Application for a non-material amendment following a grant of planning permission.
Town and Country Planning Act 1990

Residential development for 40 dwellings, including 30% affordable, with associated access, landscaping and ancillary works. Re-submission following EG/73/12. Departure from the Development Plan.

EG/29/13

Amend garage roof to plot 18 to be grey tile.

Scale	1:500 @ A2	Drawn	DGP	Checked	DGP
Date	August 2012	File	P706-Layout	Drawing Status	
Drg.No.	P706/102	Rev.	H	Planning

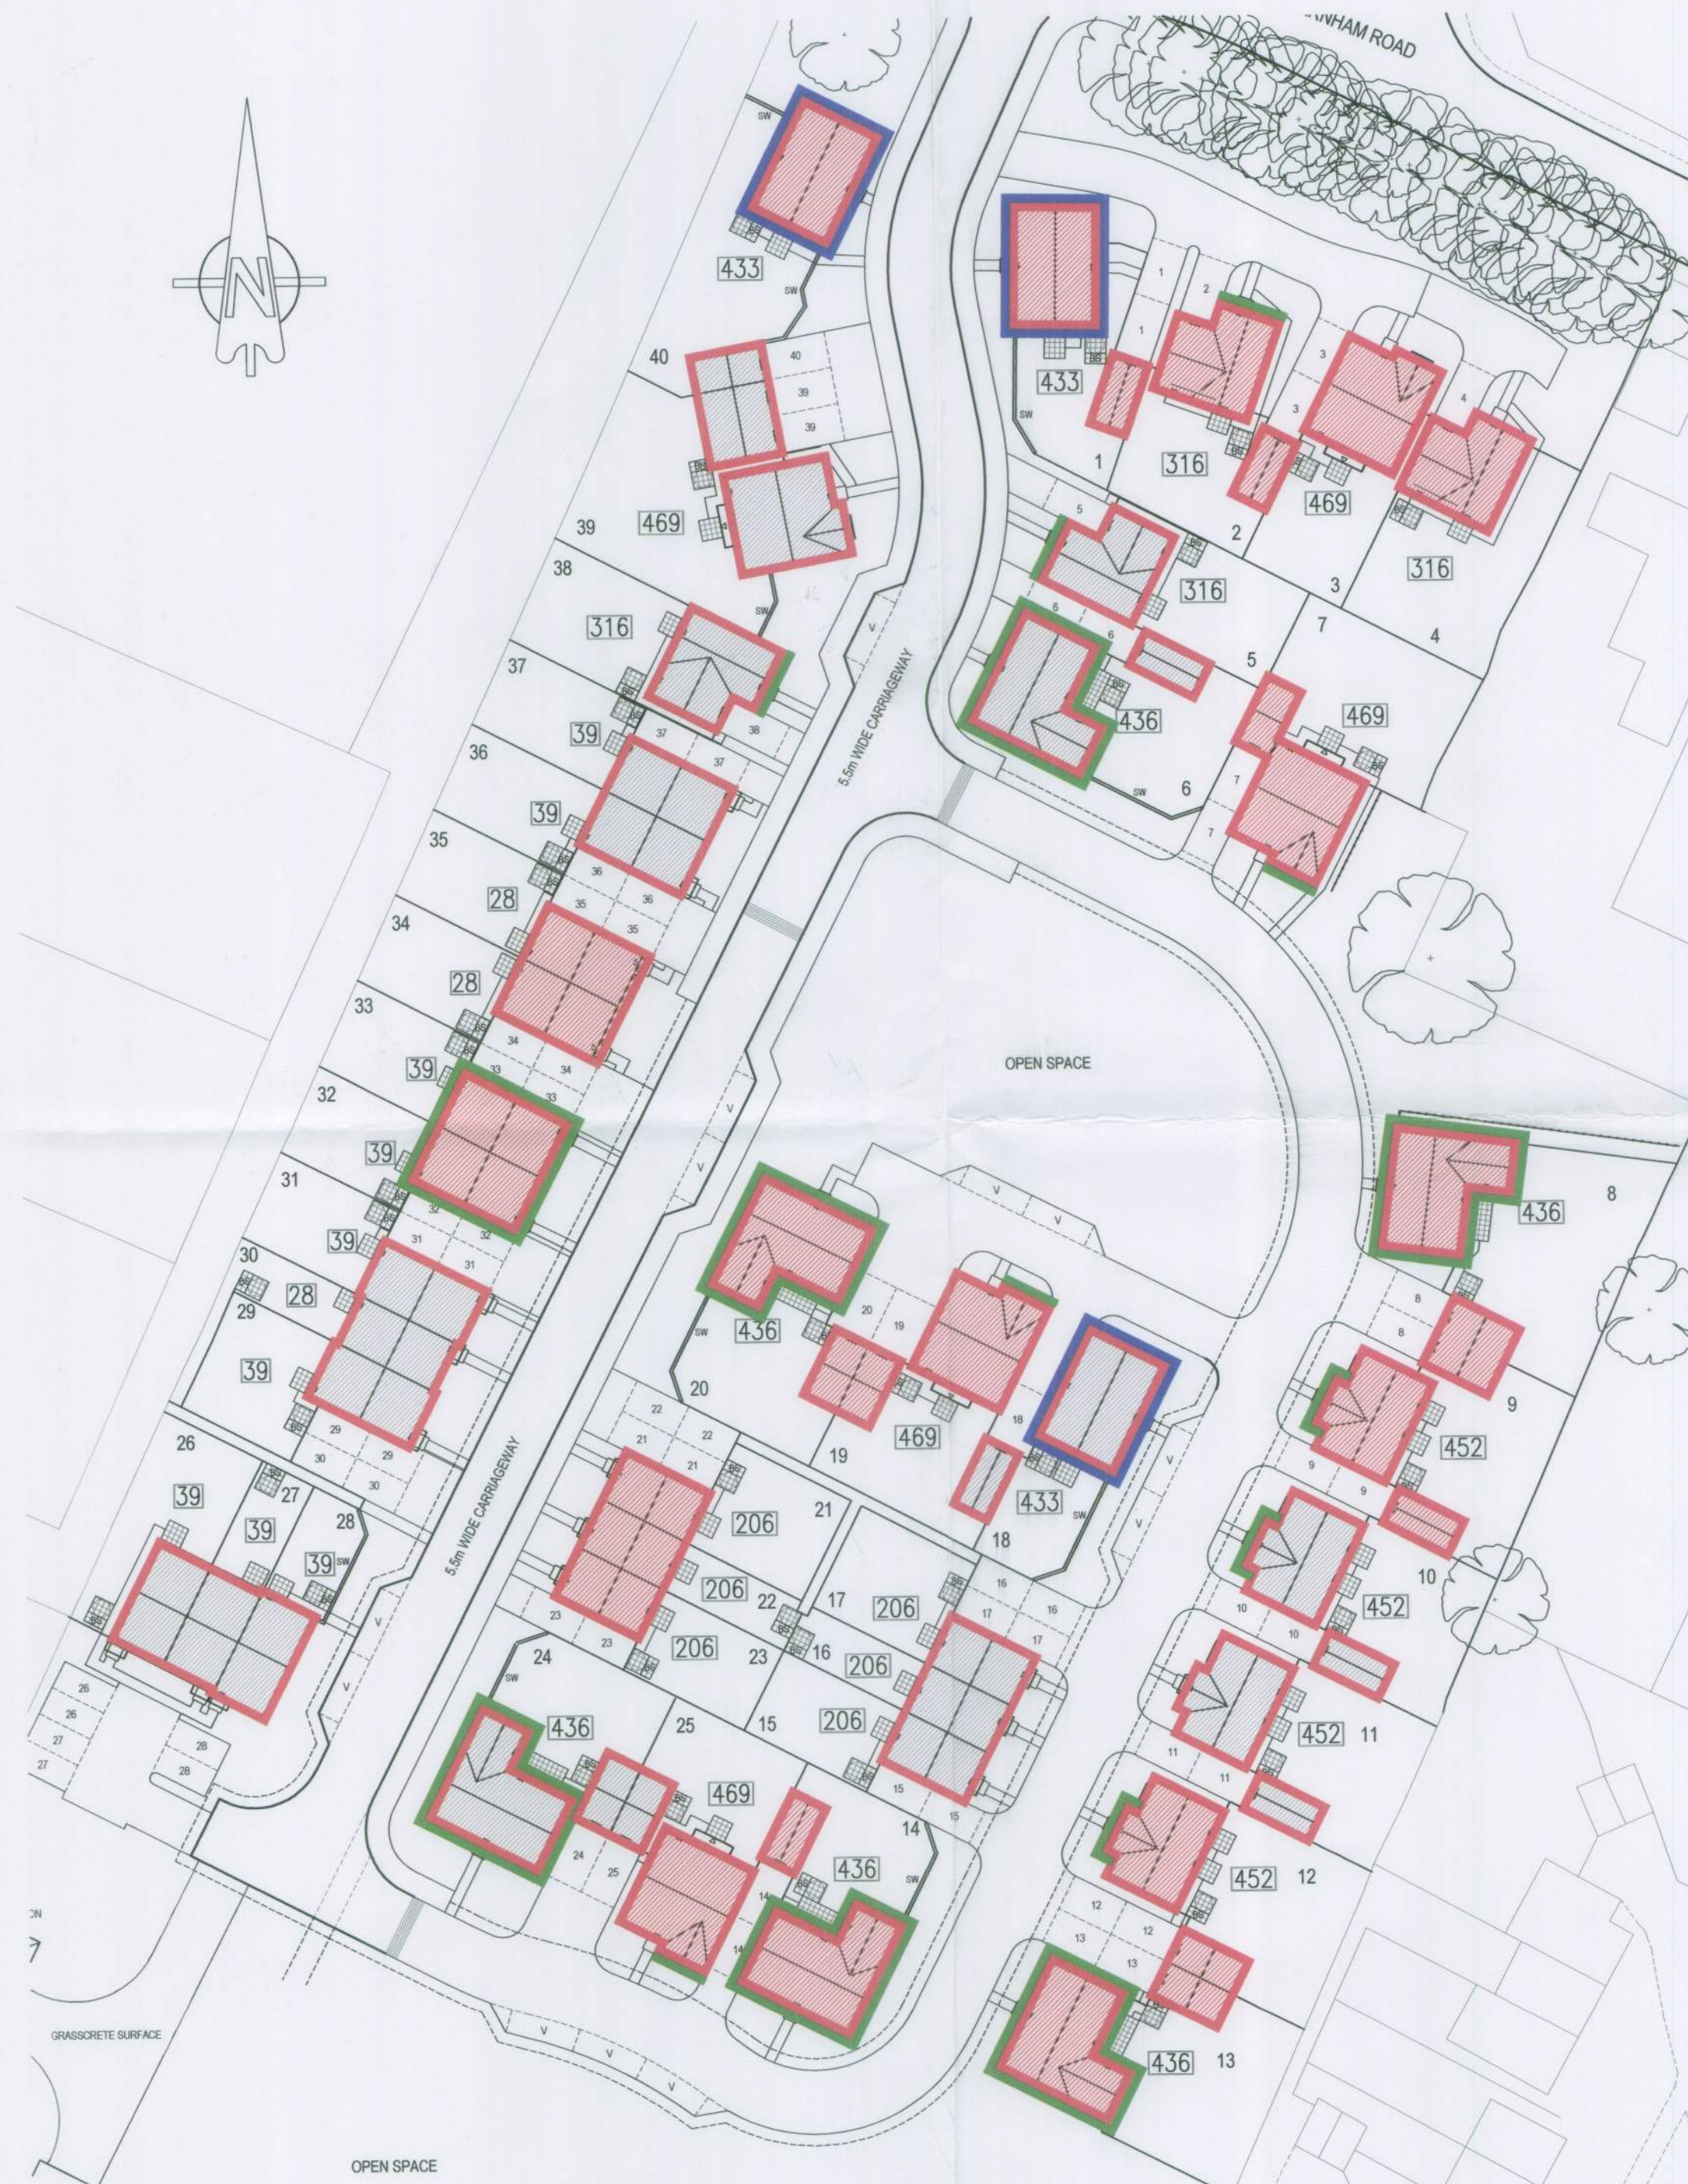
To give plot 18 the same garage roof tiles as its house.

P706/102 rev. H
